**Harnett County**  
420 McKinney Pkwy  
LILLINGTON, NC 27546  
Phone:  
Fax:

**SUBJECT: SFD2107-0054**  
**SINGLE FAMILY DWELLING**

Here are the results of all Inspections located at **156 HARBORVIEW DR:**

PLOT PLAN

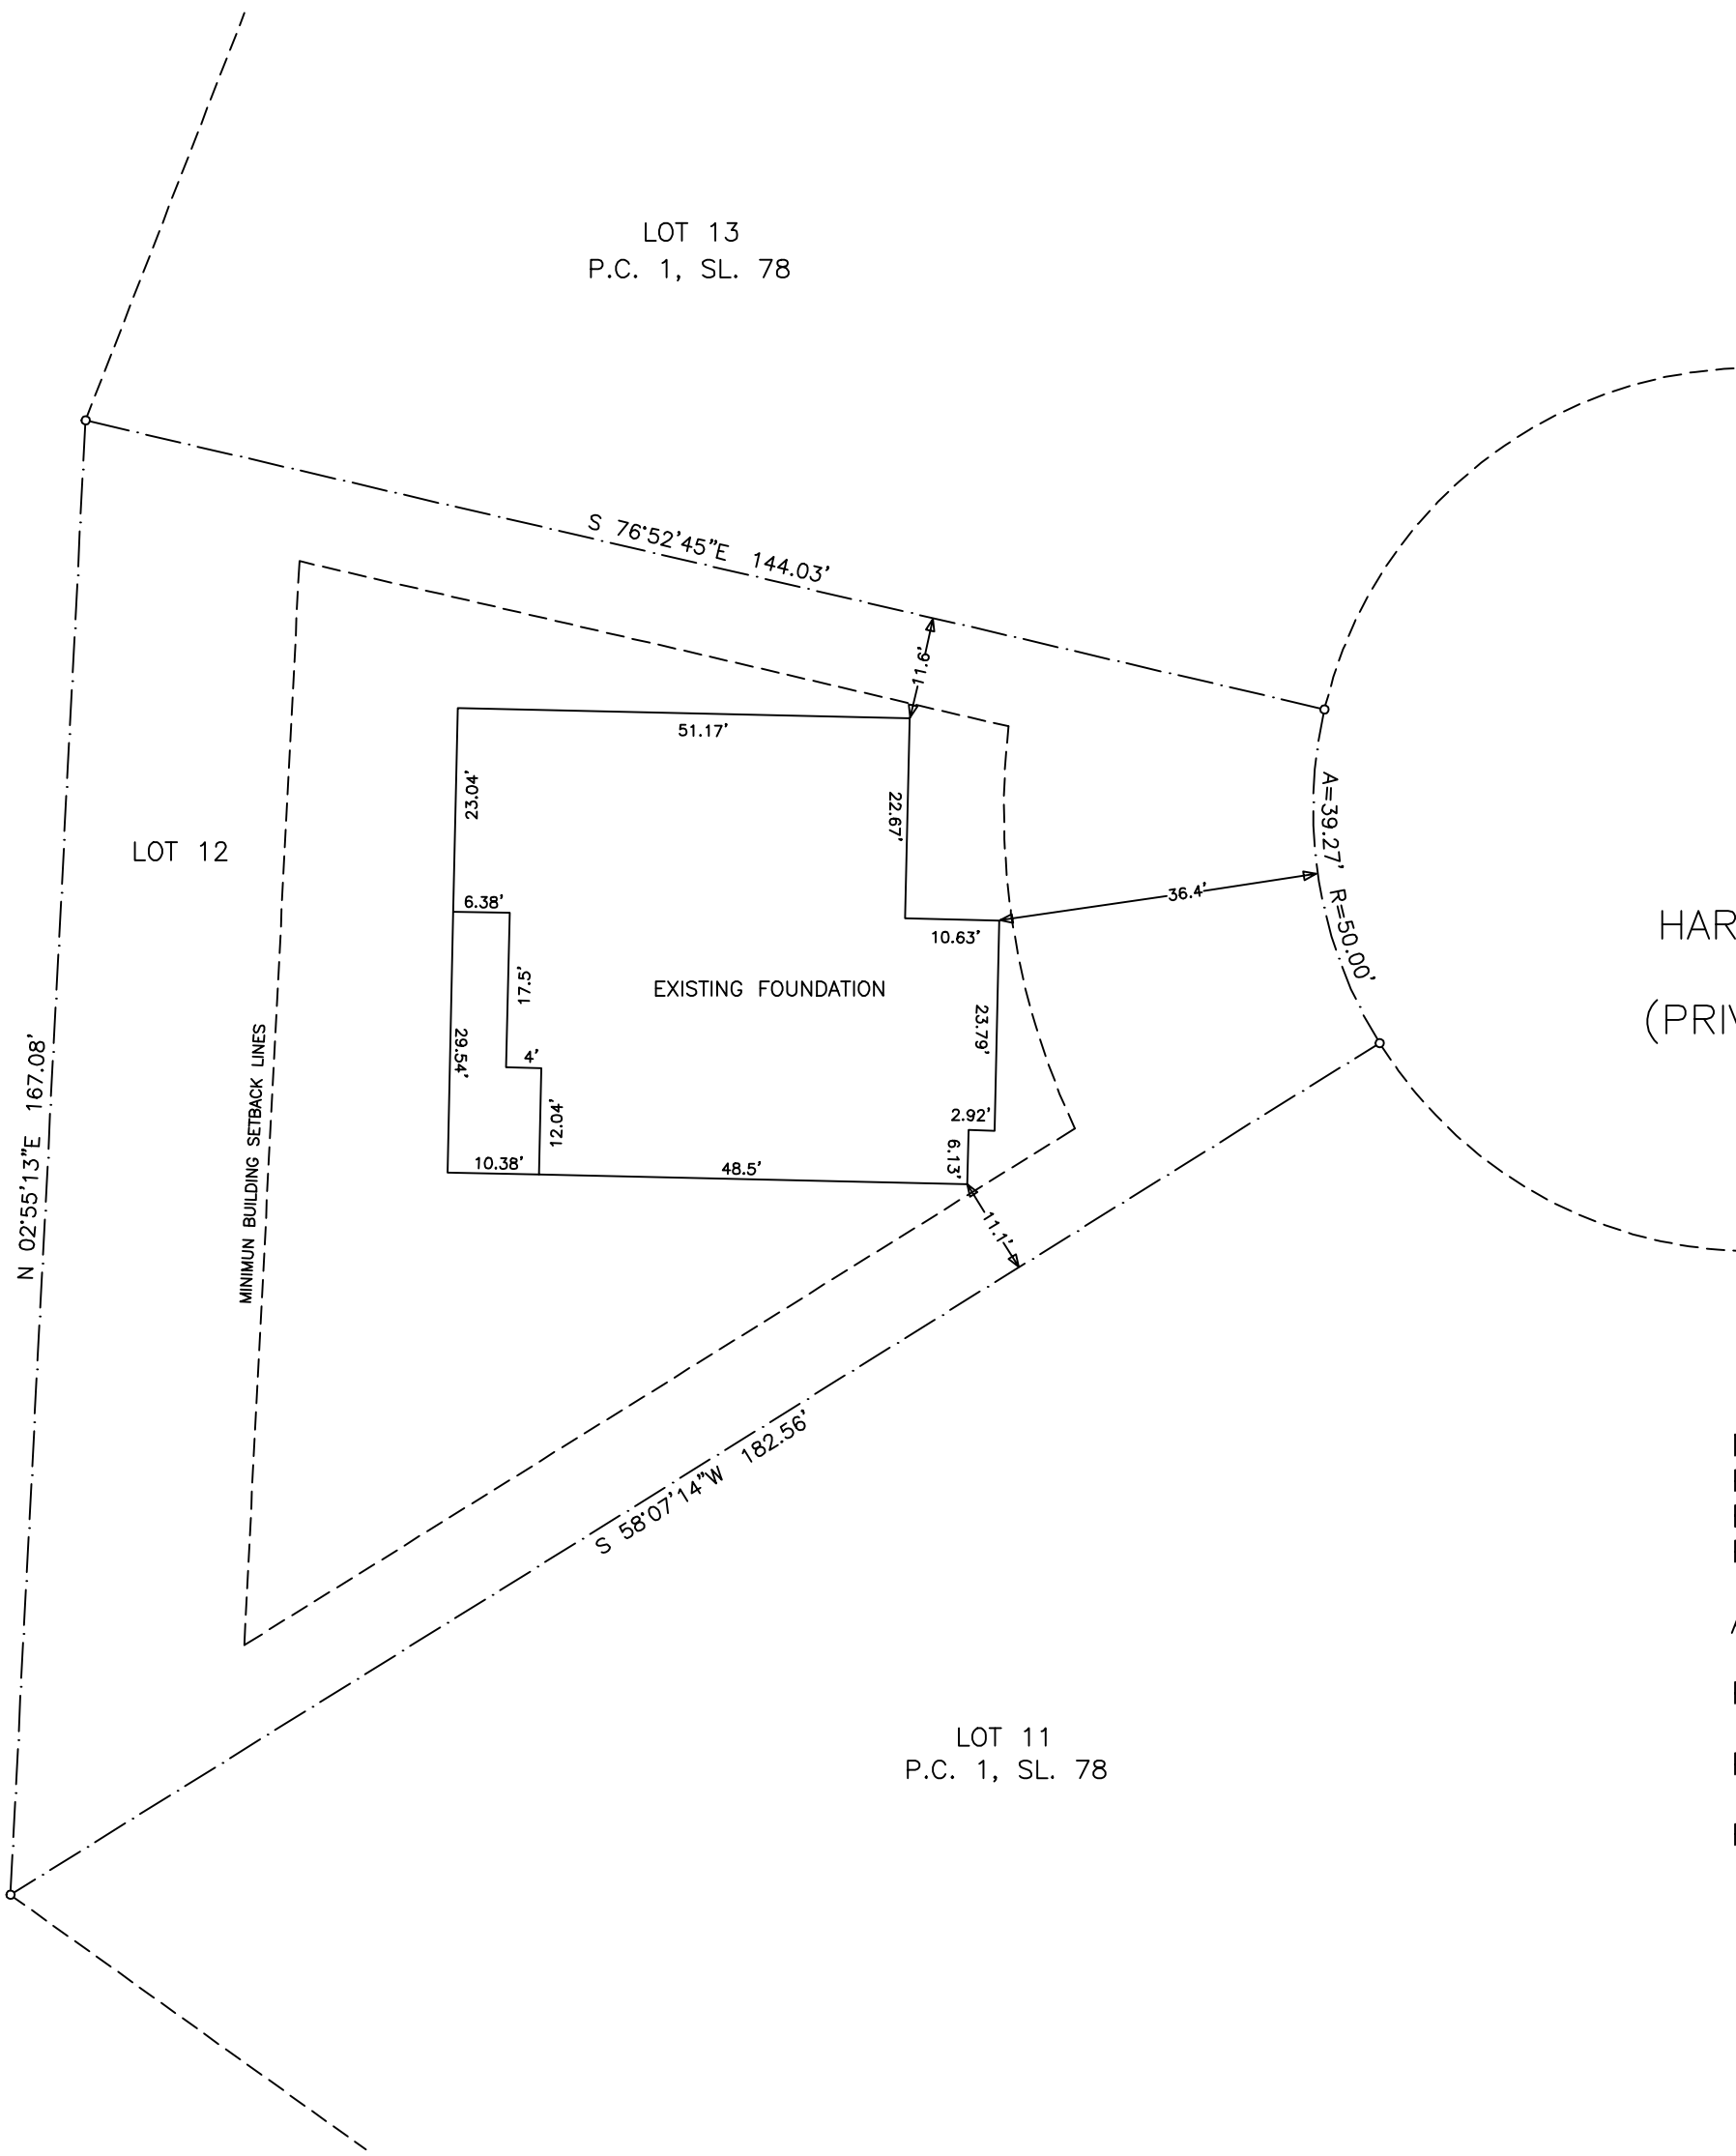
Inspector SBL changed the inspection assignment from SBL to SPG  
Update site plan to show rear deck.
